**KIRKLEES METROPOLITAN COUNCIL  
INVESTMENT & REGENERATION SERVICE**

| Reference No:         | <b>2025/62/90254/W</b>                                              |
| Site Address:         | 8, Heys Road, Thongsbridge, Holmfirth, HD9 7SD                      |

## HOUSEHOLDER DELEGATED REPORT

Elevations as Proposed

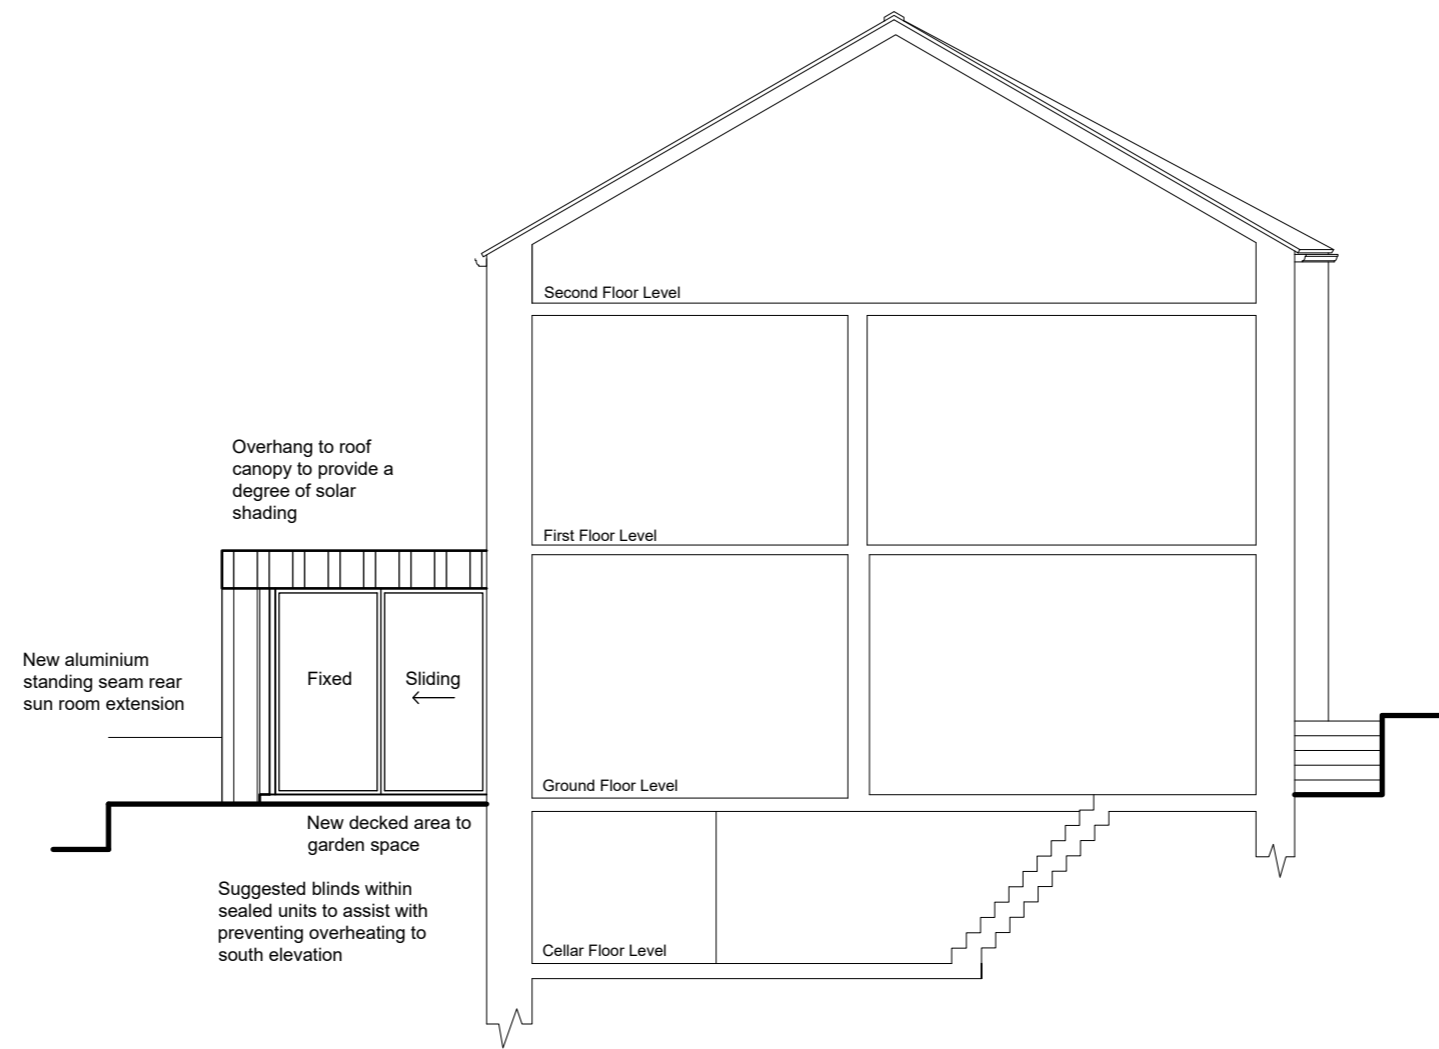
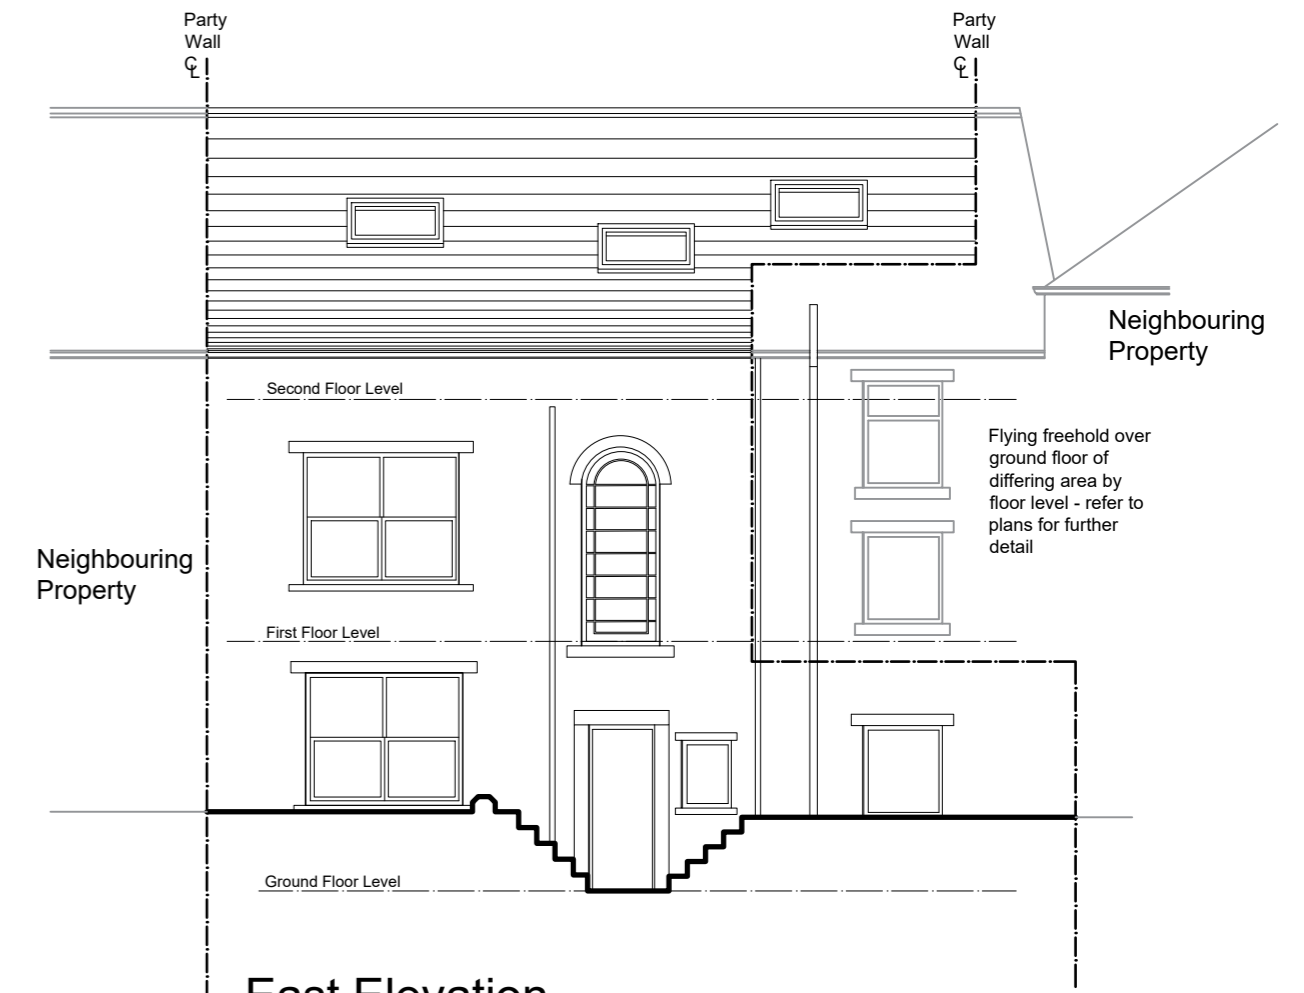
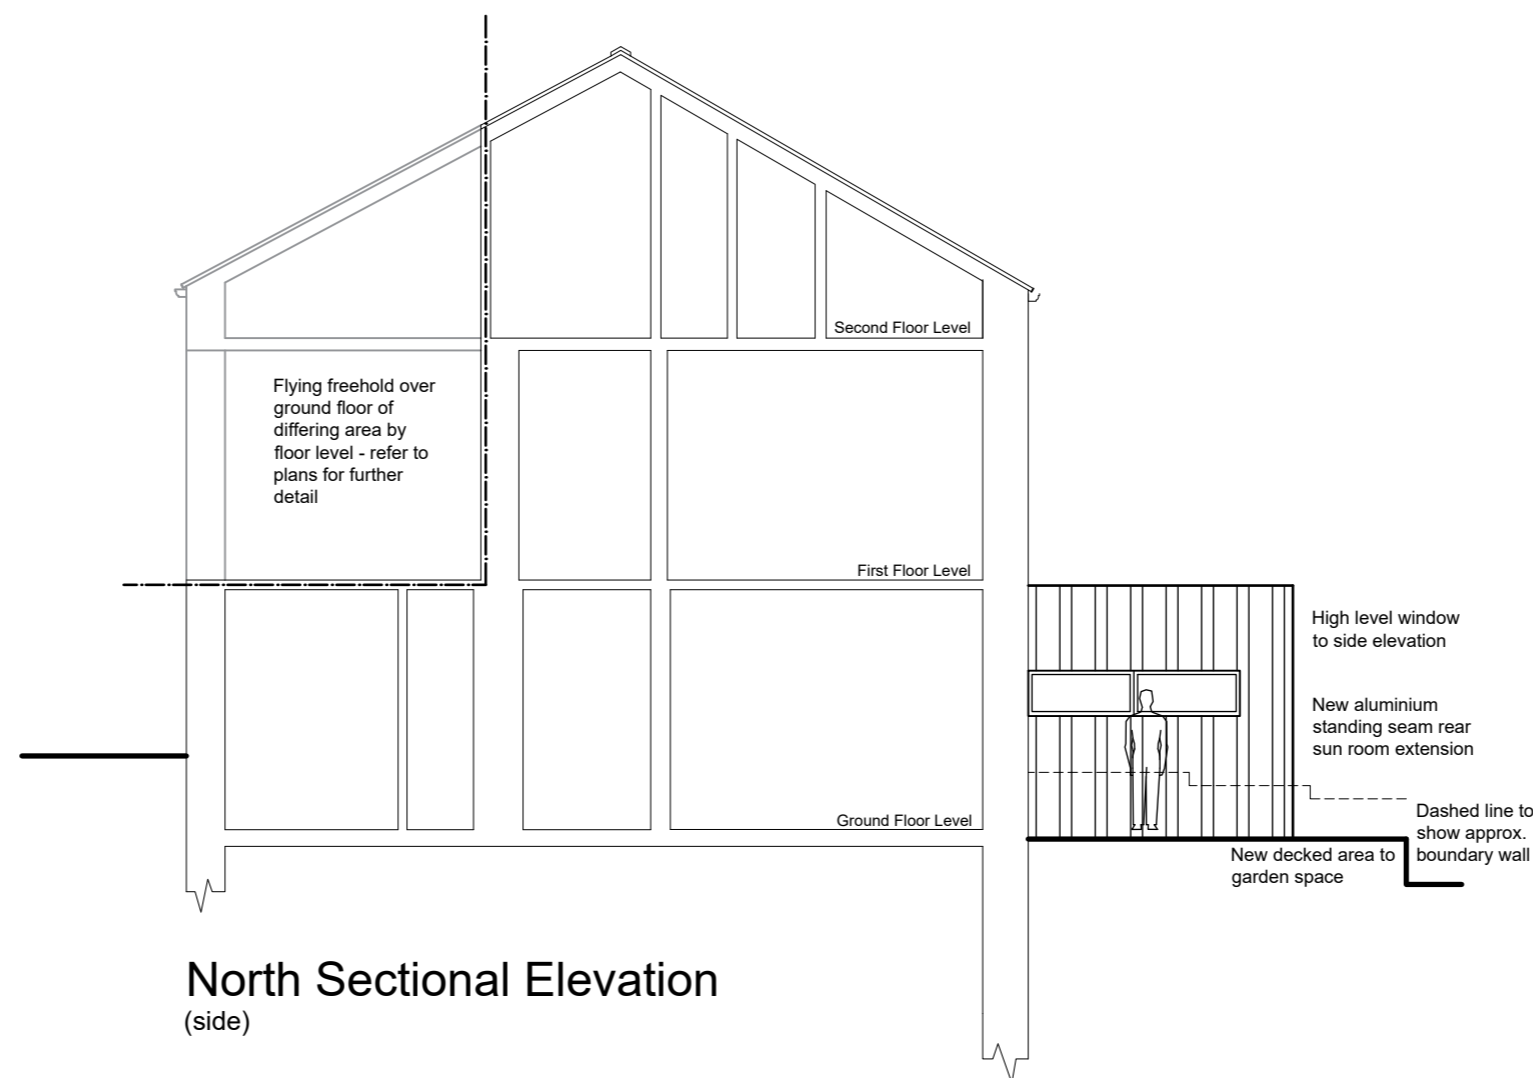
The proposed rear extension would project 3.49m from the rear elevation of the existing building, with a maximum height of 3.35m, eaves height of 2.85, and a width of 5.51m.

| not project out more than 3 metres from the rear wall of the original house for semidetached and terraced houses or by 4 metres for detached properties |                                                                 | The extension is set to project 3.49m from the rear wall of the original house, which exceeds the 3m allocation for terraced properties. However, as the extension is not deemed to have any significant impact by way of visual or residential amenity, the increase is considered acceptable in this case. |
| where they exceed 3m in length the eaves height should generally not exceed 2.5 meters                                                                  |                                                                 | The eaves height of the extension is to be 2.85m where the proposal exceeds 3m in length, however, as aforementioned due to the extension not having any significant impact on surrounding dwellings, this increase is also considered acceptable.                                                           |

| Facing materials and detailing | <ul style="list-style-type: none"> <li>KDP 9 of the SPD</li> <li>Policy LP24 Design (d) (iii) of the KLP</li> <li>Chapter 12 of the NPPF</li> </ul>              | The extension is to be faced in standing seam aluminium walls rather than the existing natural stone and rendered masonry. Furthermore, the windows and doors are proposed to be powder coated aluminium rather than the existing uPVC windows in the house. However, as the extension is small in scale with the standing seam being minimal and the property backs onto open land, the materials are not considered to have any significant impact with regard to visual amenity and can be considered acceptable. | ✓ |
| Roof style                     | <ul style="list-style-type: none"> <li>KDP 1 and 2 of the SPD</li> <li>Policy LP24 Design (a), (c) and (d) of the KLP</li> <li>Chapter 12 of the NPPF</li> </ul> | The roof is proposed to be a EPDM/Fibre Glass Flat Roof rather than a stone slate roof to match the existing house, however, as aforementioned non-matching sympathetic materials can be considered acceptable in this instance.                                                                                                                                                                                                                                                                                     | ✓ |

3. The external walls of the extension hereby approved shall in all respects be constructed using steel/timber frames with standing seam aluminium in a Copper Brown colour finish.

Floor Plans as Proposed

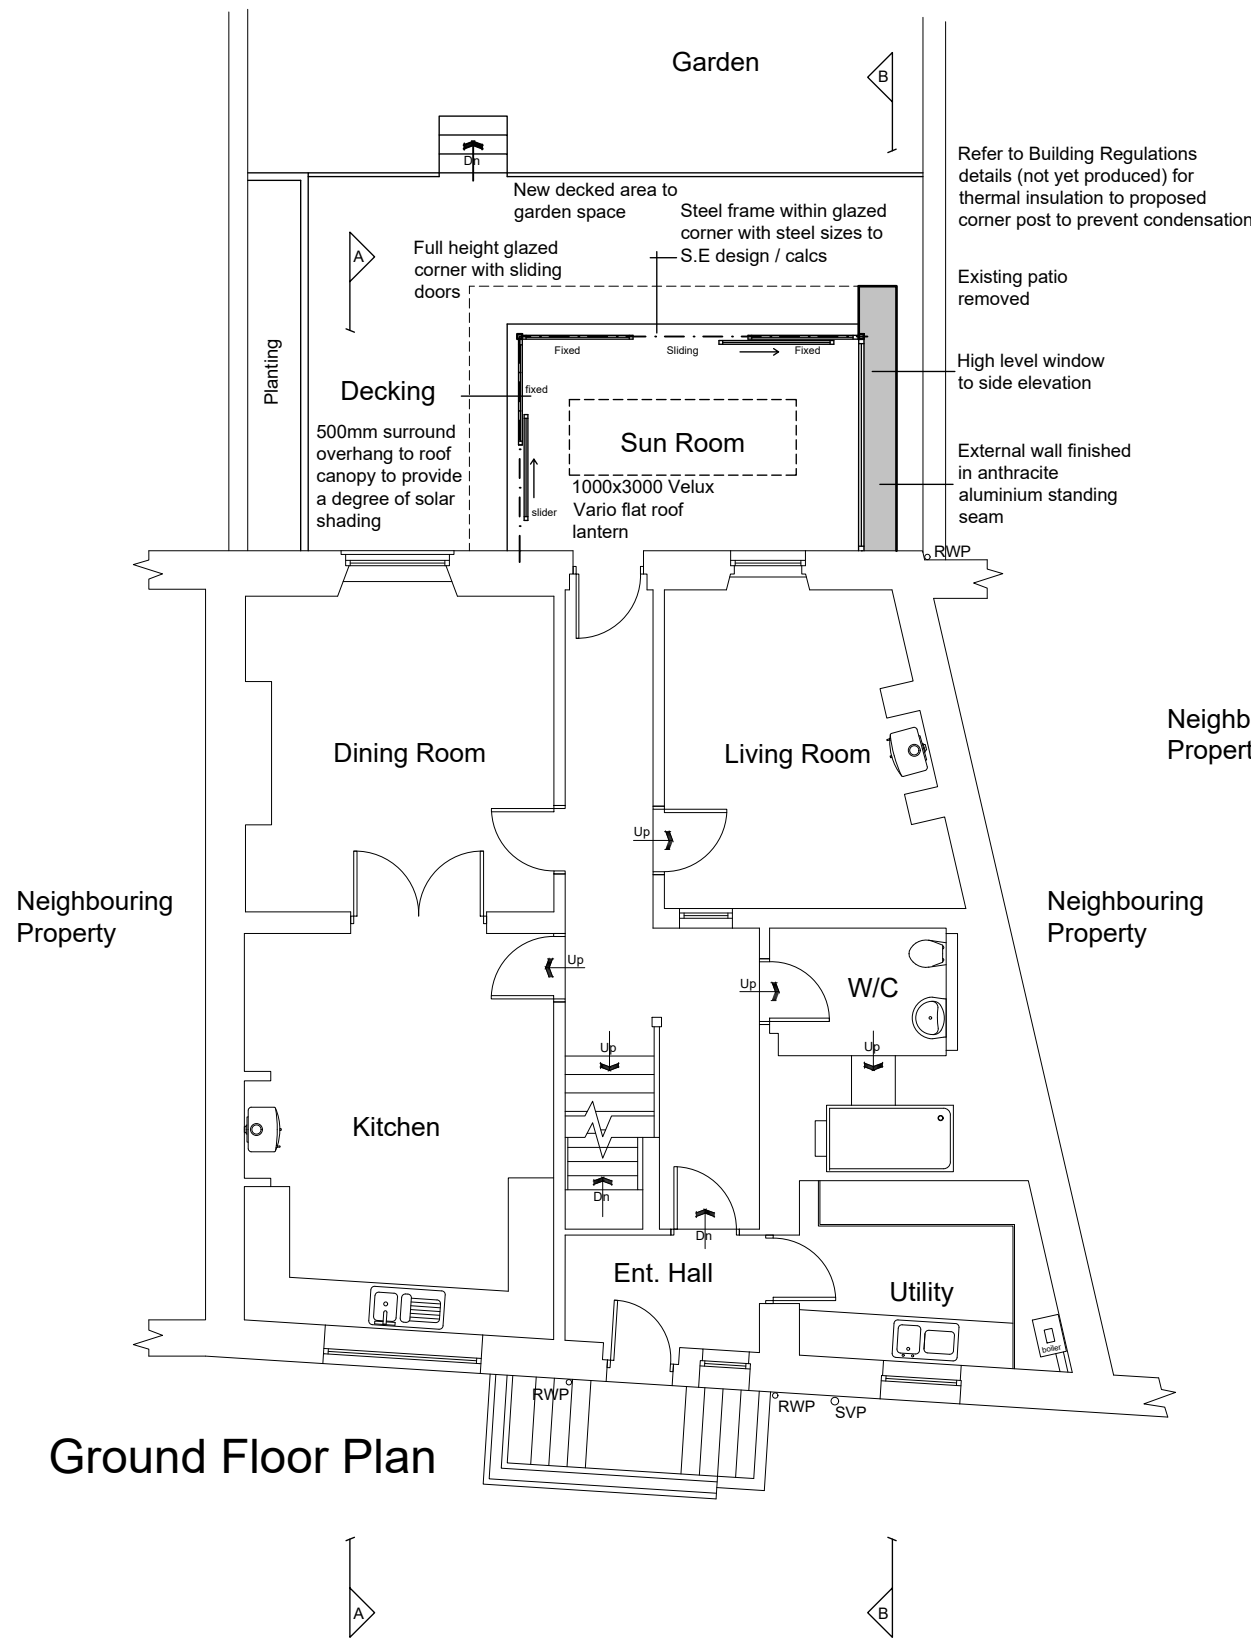
| retain a gap of at least 1 metre from a property boundary, such as a wall, fence or hedge                                                               |                                                                 | A gap of only 0.35m is retained to the South property boundary, however, this will have no significant impact on habitable neighbouring windows and is therefore considered acceptable.                                                                                                                      |
